DECISION DELEGATED TO HEAD OF PLANNING

Application No: H23-0822-22 **Applicant:** Mr D Burchnall
Proposal: Residential Development
Location: Broadgate Whaplode Drove Spalding
Terminal Date: 14th October 2022

Outline planning permission is sought for 2 new dwellings with all matters reserved.

SITE PLAN
1:250

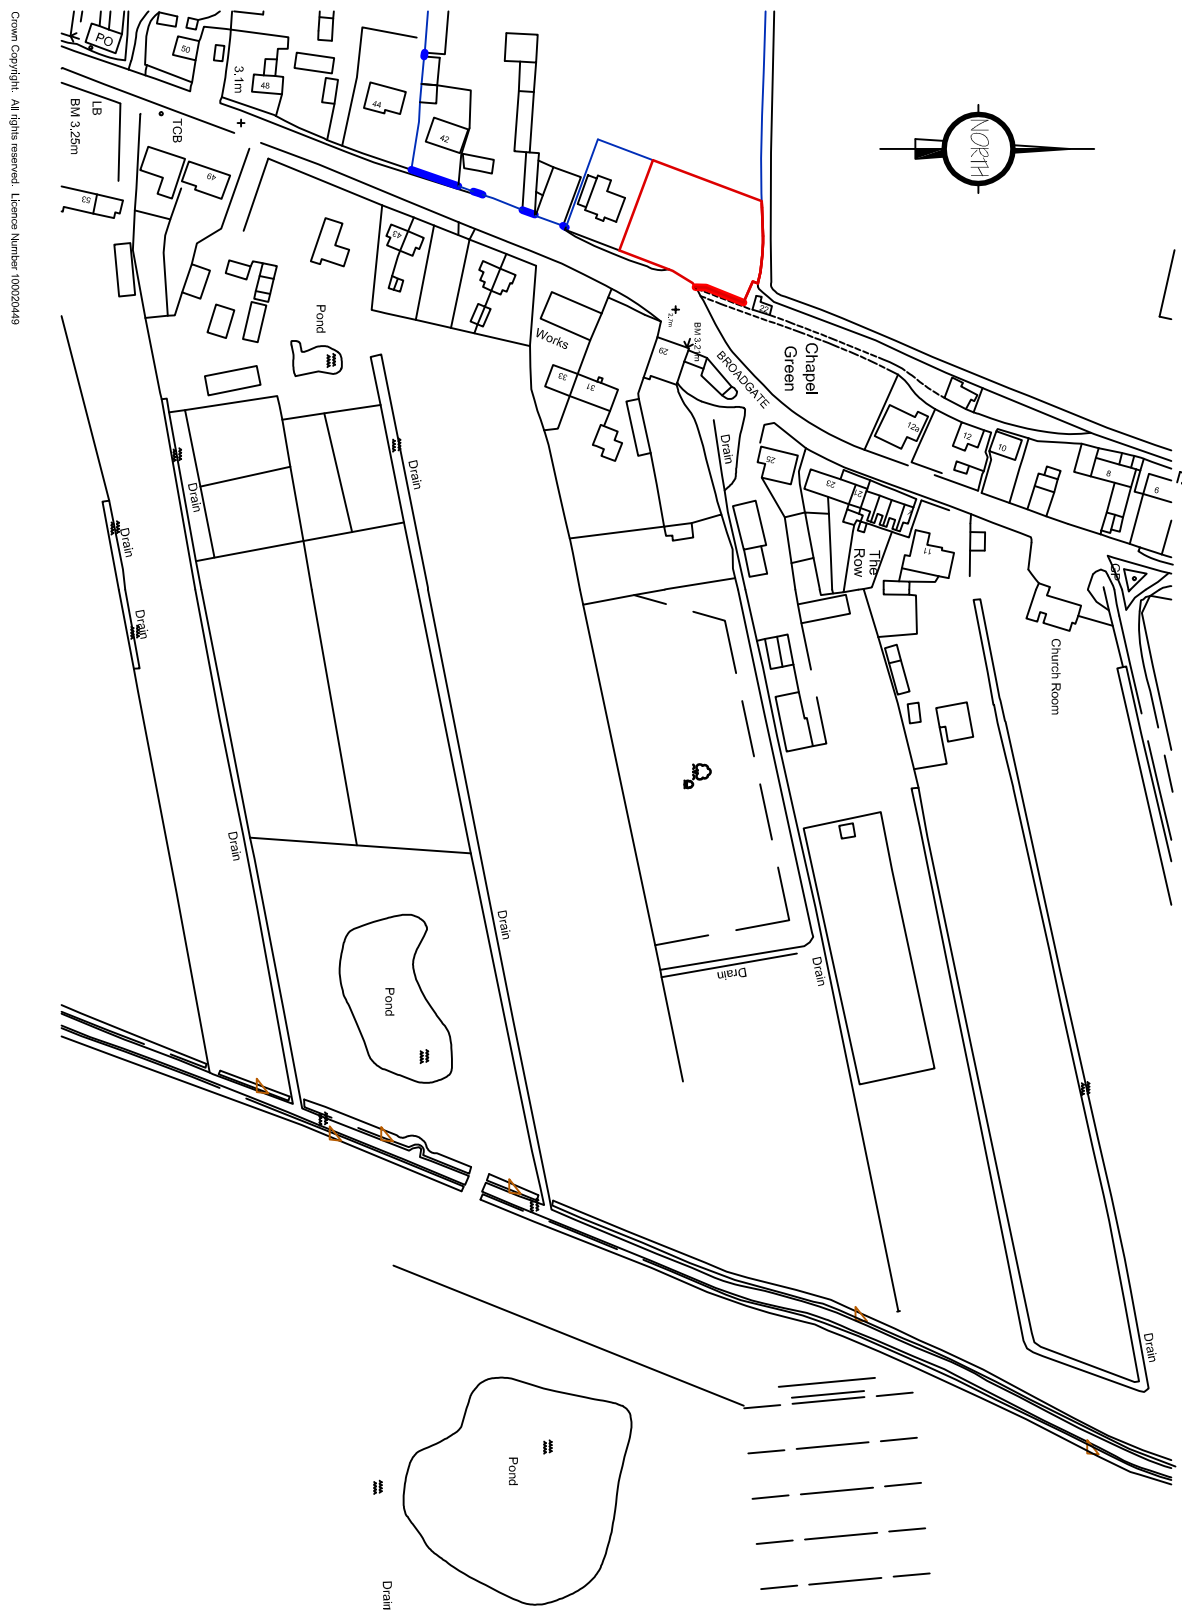
The proposed indicative plan show plot 2 being sited close to the shared boundary with the newly constructed dwelling to the south-west of the site at no34 Broadgate. The dwelling is show approximately 5.5 metres from the nearest elevation of this neighbour. It would have a similar set-back to this neighbour. Subject appropriate location of primary windows it is not considered that any unacceptable impact would result.

With regards to the neighbour to the north-east at no.22 Broadgate plot 1 would be the closest to this neighbour as shown on the indicative plan. This dwelling would be sited a sufficient distance from this neighbours closest elevation. As such it is not considered that any overbearing impact or unacceptable overshadowing would result. In addition, there are high level trees along the north-eastern boundary which further reduce any potential impact.

Plot 1 shows a garage and driveway which can accommodate at least 3no vehicles therefore this meets the maximum parking standards. Plot 2 shows a driveway for 2no vehicles, however, there is space to the front of the proposed dwelling for further off-street parking.
